From: [Candie Leader](#)
To: [Rachael Stevie \(CD\)](#)
Subject: RE: BL-20-00030 US Bureau of Reclamation - Request for Survey Review (2)
Date: Tuesday, February 2, 2021 9:28:07 AM
Attachments: [image001.png](#)
[image002.png](#)

Subject: Fw: [EXTERNAL] RE: Revised Preliminary BLA, BL-20-00030

My responses to the Kittitas County comments regarding BLA BL-20-00030 are as follows:

BOUNDARY LINE ADJUSTMENT FOR U.S. BUREAU OF RECLAMATION
DRAWN BY: KDB DATE: 6/1/2020 REV. BY: KDB DATE: 2/01/2021 PROJECT MANAGER: KDB SCALE: 1" = 1000'
DRAWING FILE NAME: 1702303_BLA.DWG CHK BY: SPJR JOB NO. 17-023-03 SHT. NO. 1 OF 6

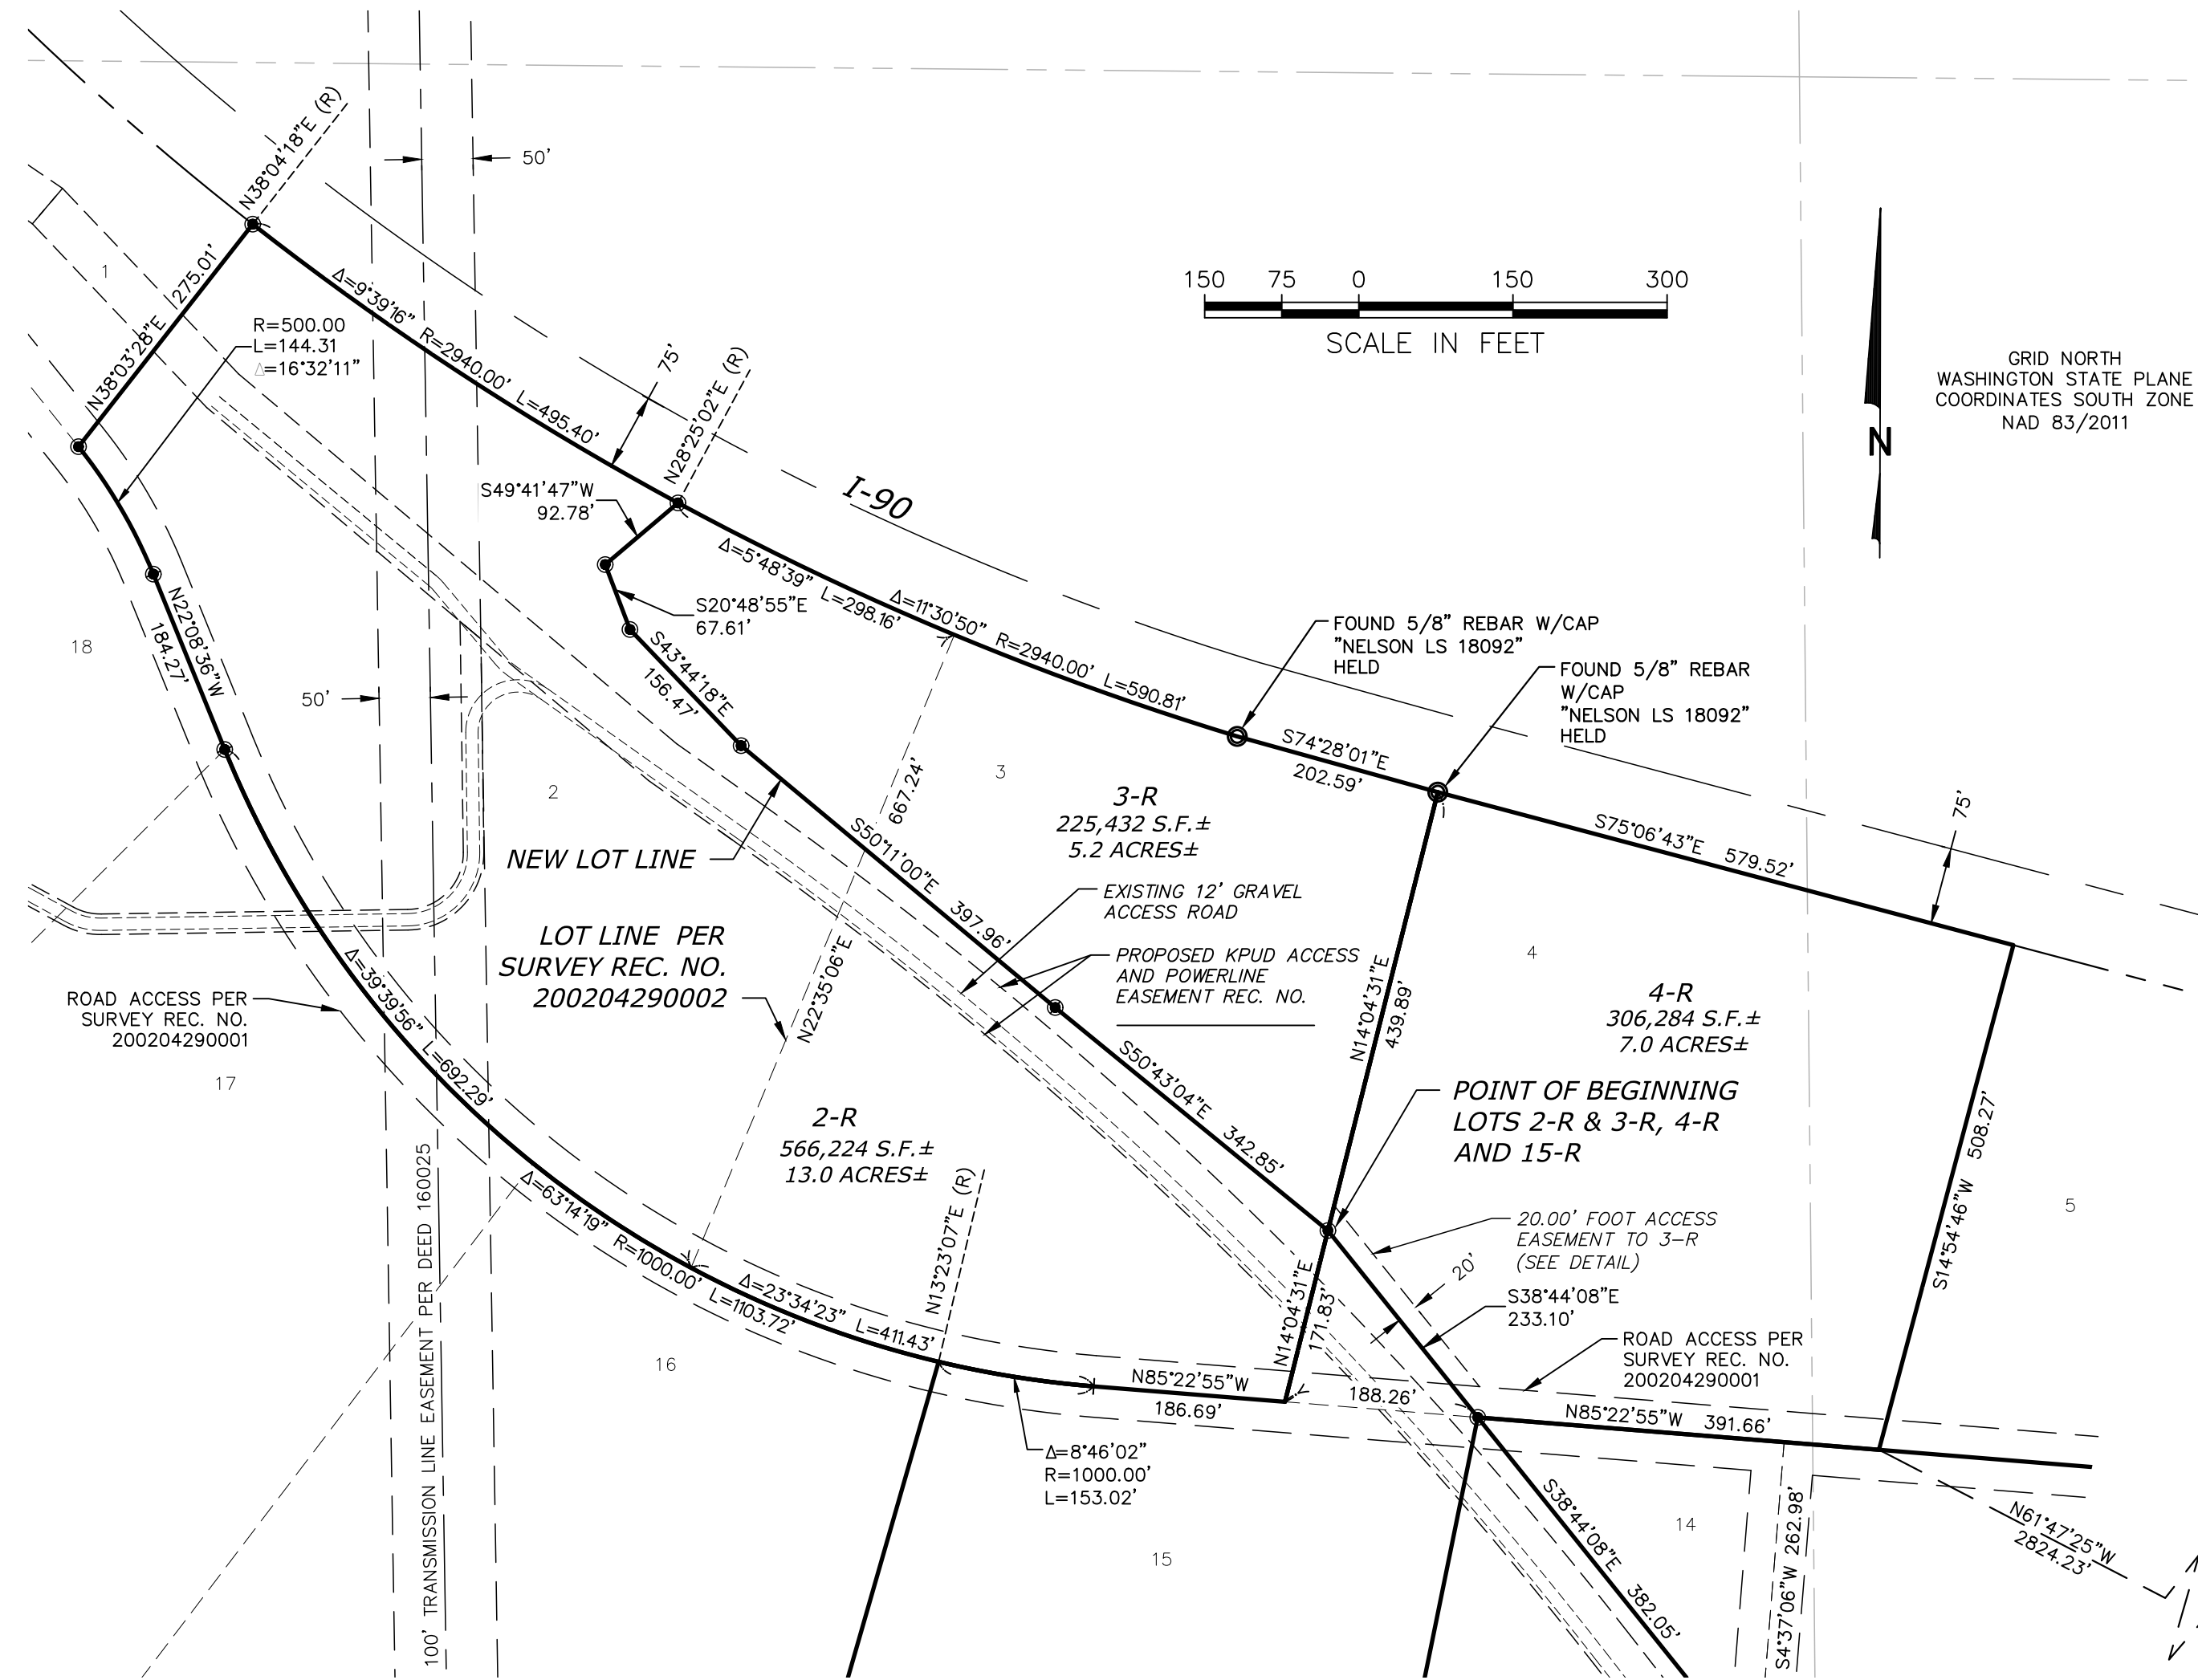
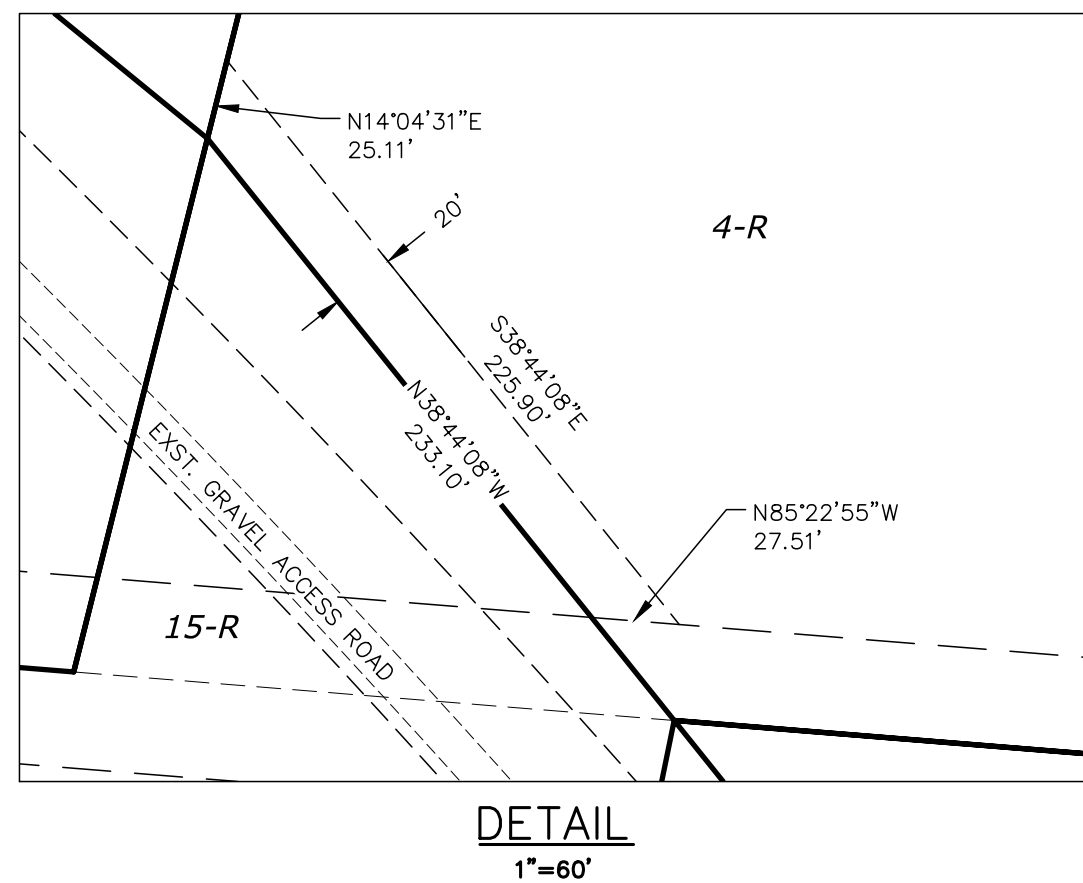
I sent the revised survey to Public Works for review and they noted that their survey comments from 12/22/2020 (see attached), had not been addressed.

- Item 1, page 1 – all access easements are shown on the face of the BLA map, resolving the access to lots 16 and 17.
- Item 1 page 2 – References to Lot 21 and application BL-20-00030 were added to the survey narrative.
- Item 2 page 2 – Surveyor's Certificate was revised to list U.S. Bureau of Reclamation as the client.
- Item 3, page 2 – Crows feet were added to the curve on the south boundary of Lot 2-R to clarify dimensioning.
- Item 4, page 2 – Bearing and distance were added to NE line of lot 15-R.
- Item 5, page 2 – All new legal descriptions were edited to read "LOT ____ OF THAT CERTAIN SURVEY RECORDED _____, 2021, IN BOOK _____, PAGE _____, UNDER AUDITOR'S FILE NO. _____, RECORDS OF KITTITAS COUNTY." The blanks for the legal descriptions and the PUD easement will be filled in at the time of recording.
